MECKLENBURG COUNTY
Land Use & Environmental Services Agency

MEMORANDUM

To: Charlotte-Mecklenburg Planning Commission
From: Dylan J. Kirk, Sr. Environmental Specialist
Date: Tuesday, July 27, 2021
Subject: Initial Rezoning Petition Comments

2021-085: Raven Property Group, LLC

**SITE PLAN**

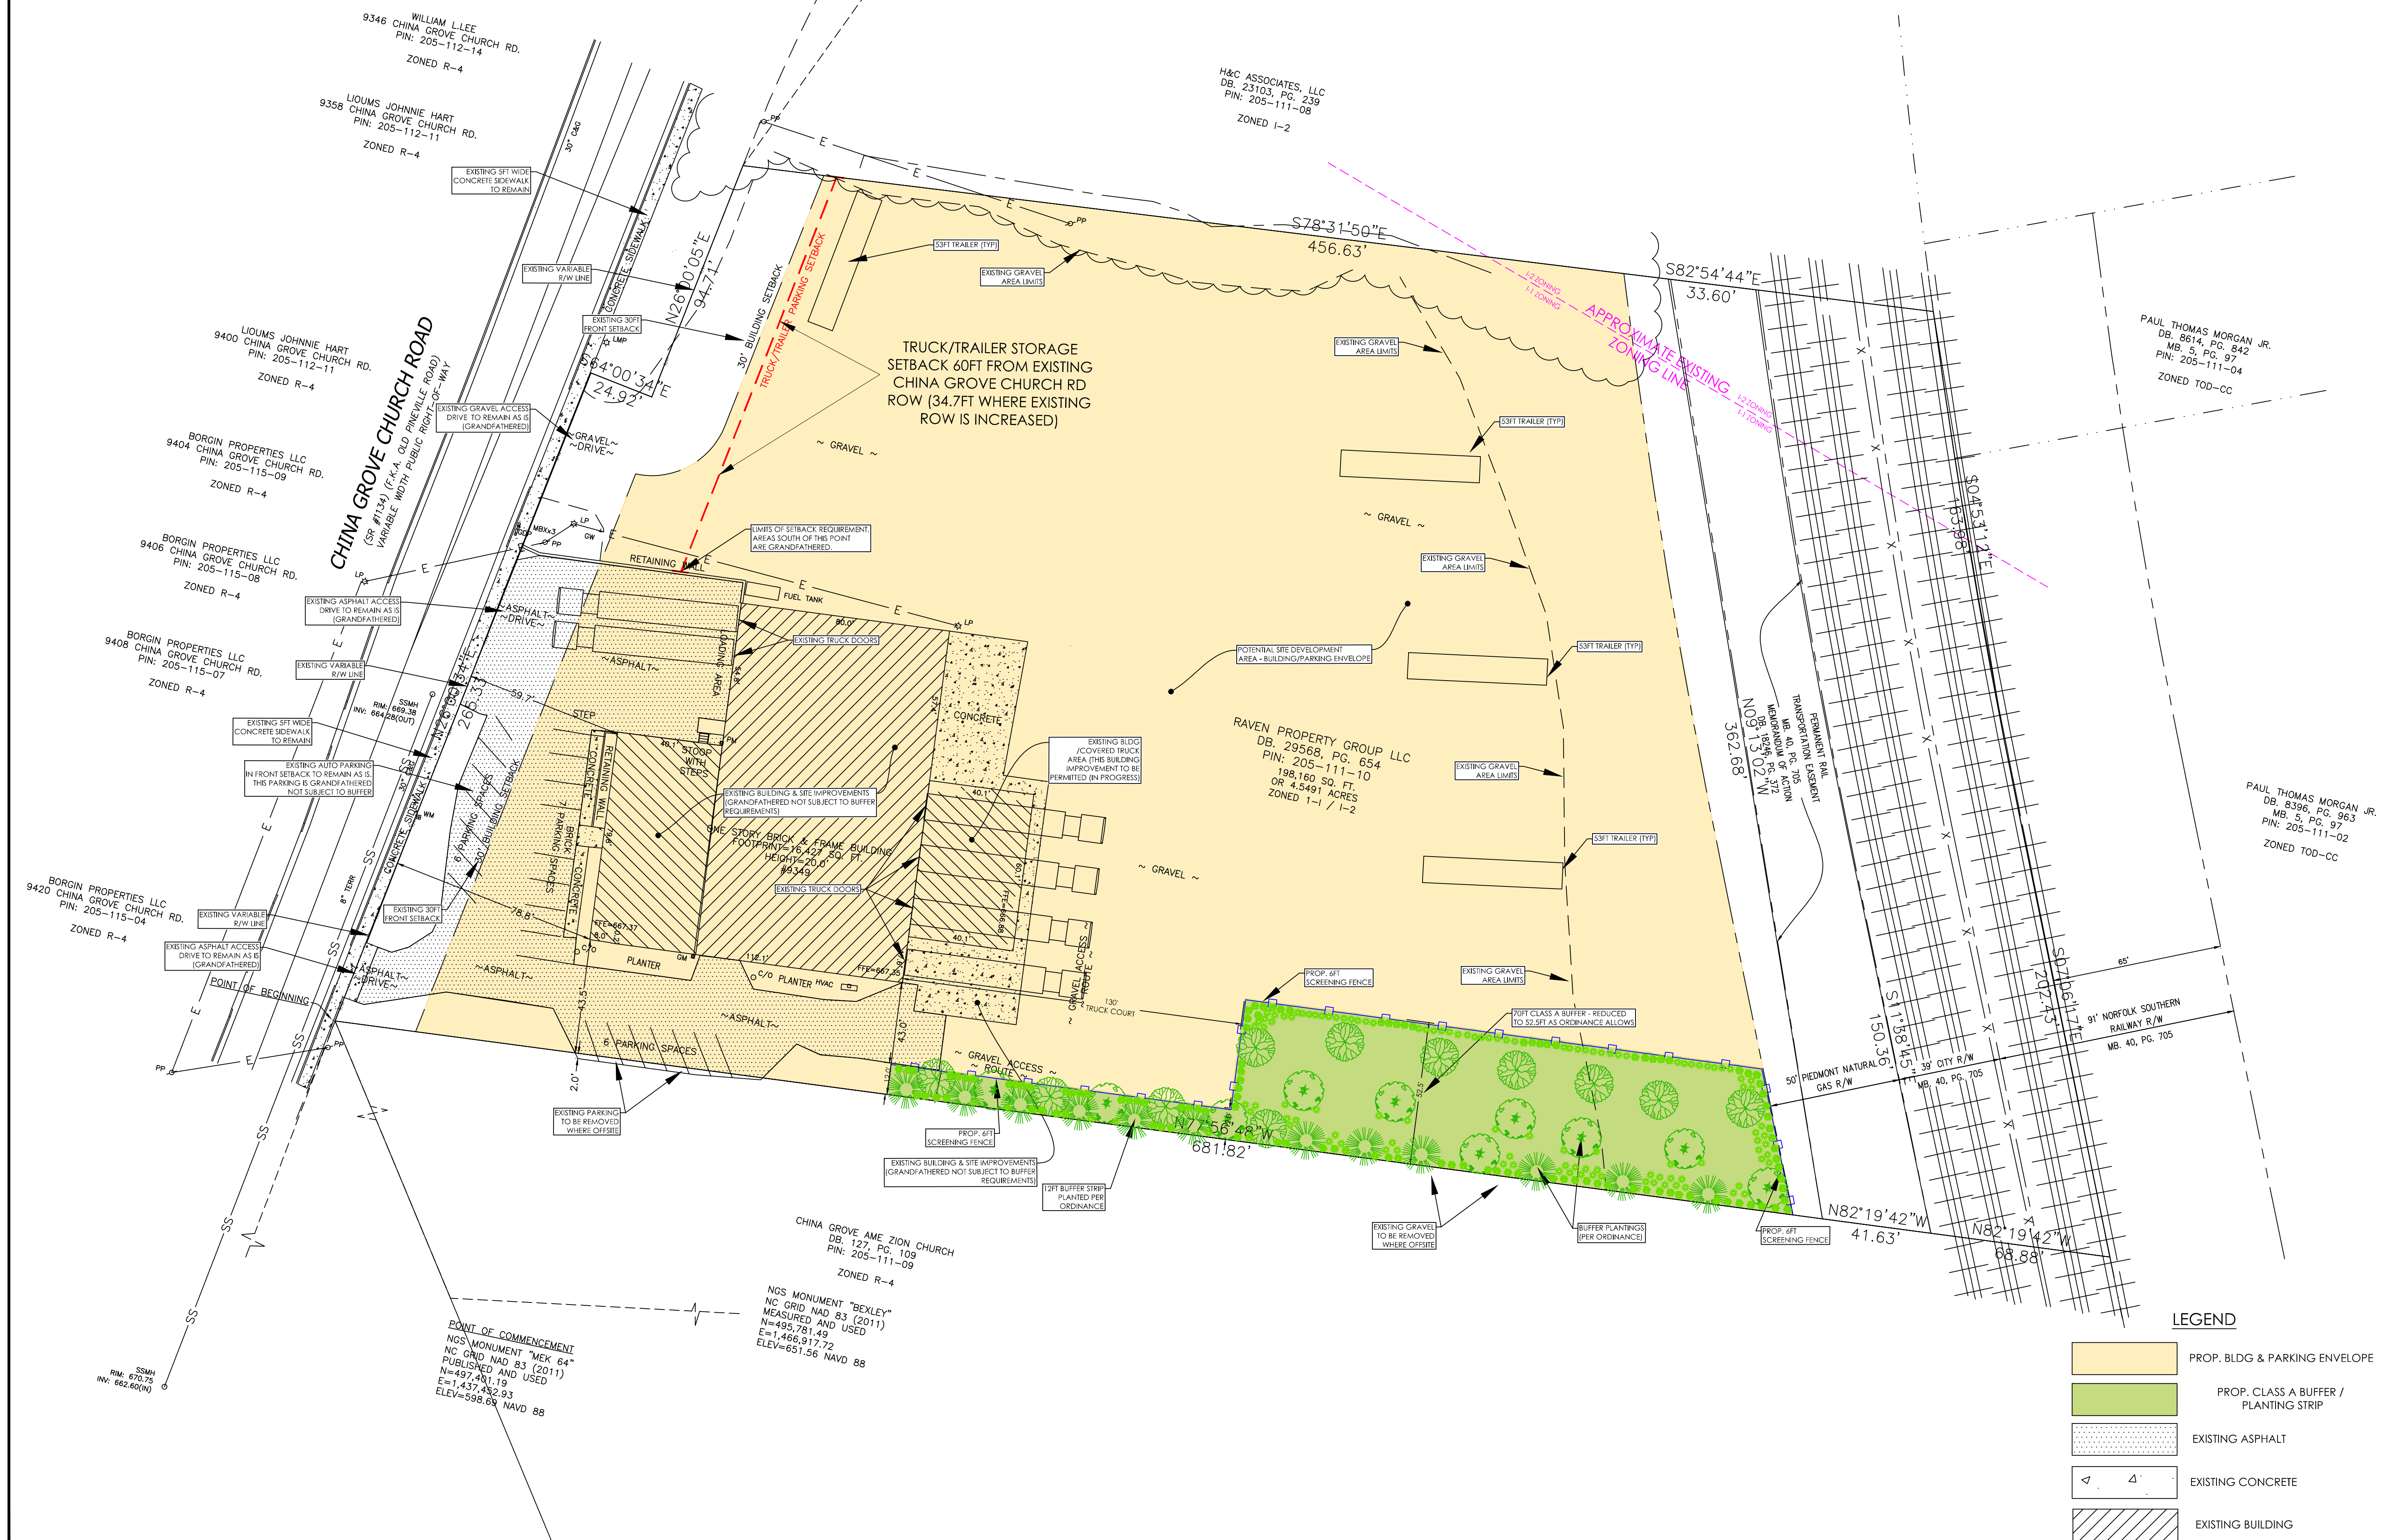
Groundwater & Wastewater Services records indicate a Subsurface Investigation Permit (SIP) was issued for parcel 205-111-10. Please note that monitoring wells on this parcel need to be located, flagged and protected prior to development or be permanently abandoned in accordance with the Mecklenburg County Groundwater Well Regulations.
